Epping to Thornleigh Third Track Proposal. Application number SSI 5132.

I/we object to the Epping to Thornleigh Third Track Proposal and consider that the EIS is inadequate and does not address the full impact of this proposal. It will cause untold damage to the health of residents and to the fabric of the Beecroft Cheltenham Heritage Conservation Area. Do not approve this project, reconsider the alternatives and protect the community.

Figure S.6 Cross-section and elevation - New Cheltenham Station concourse building (see also S.5 for artist's impression)

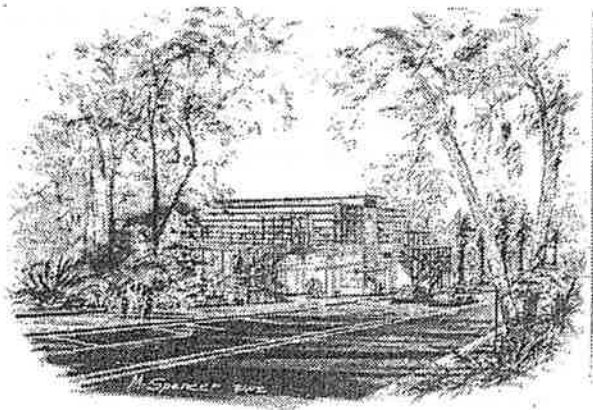
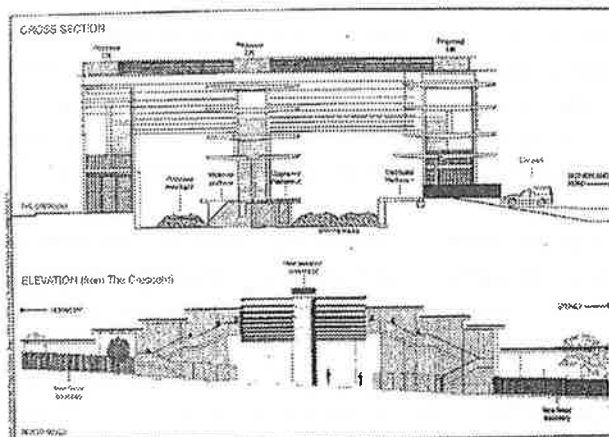
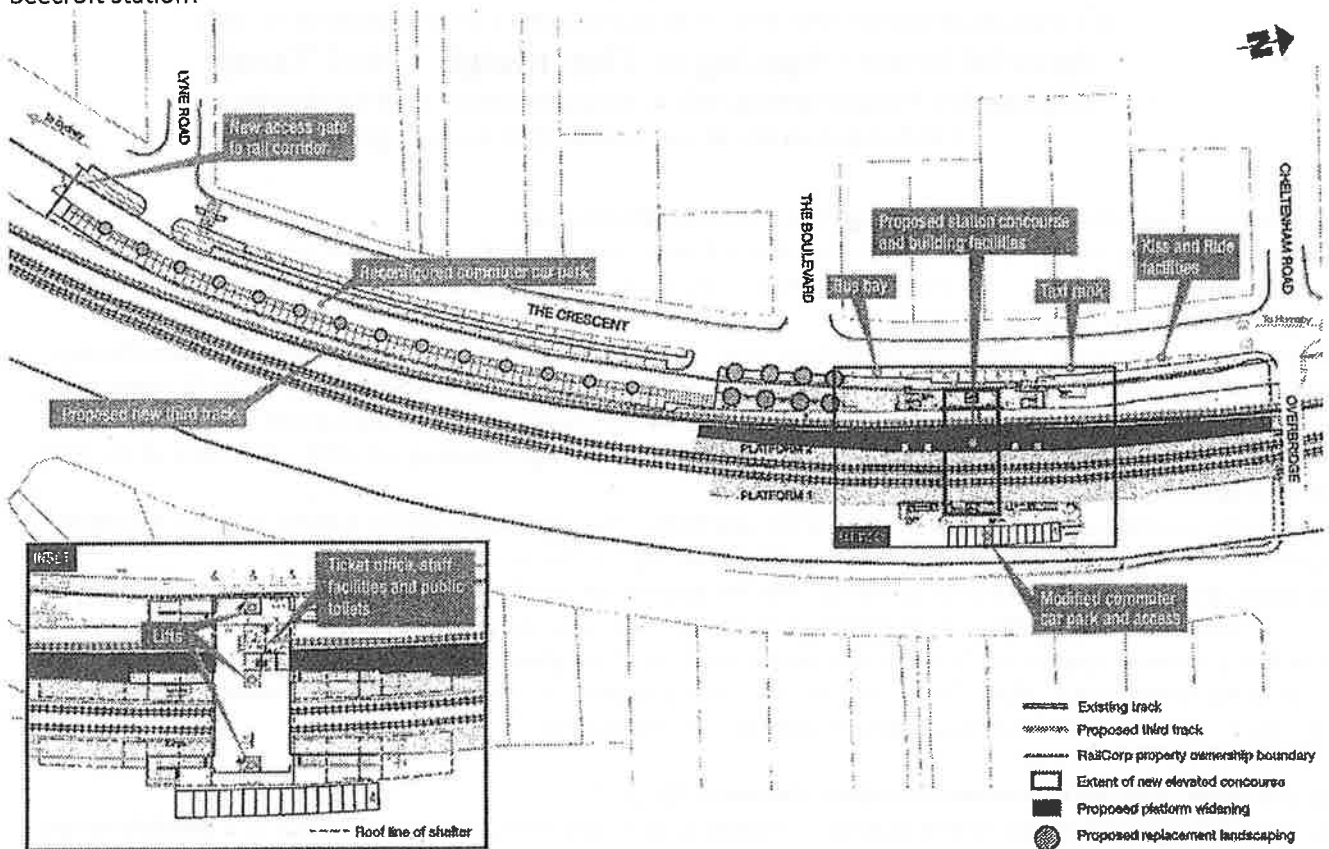
- The proposed redevelopment of Cheltenham Station shows no regard for the HCA. The visual impact of the proposed 13m high glass and steel concourse is totally unacceptable in this HCA.
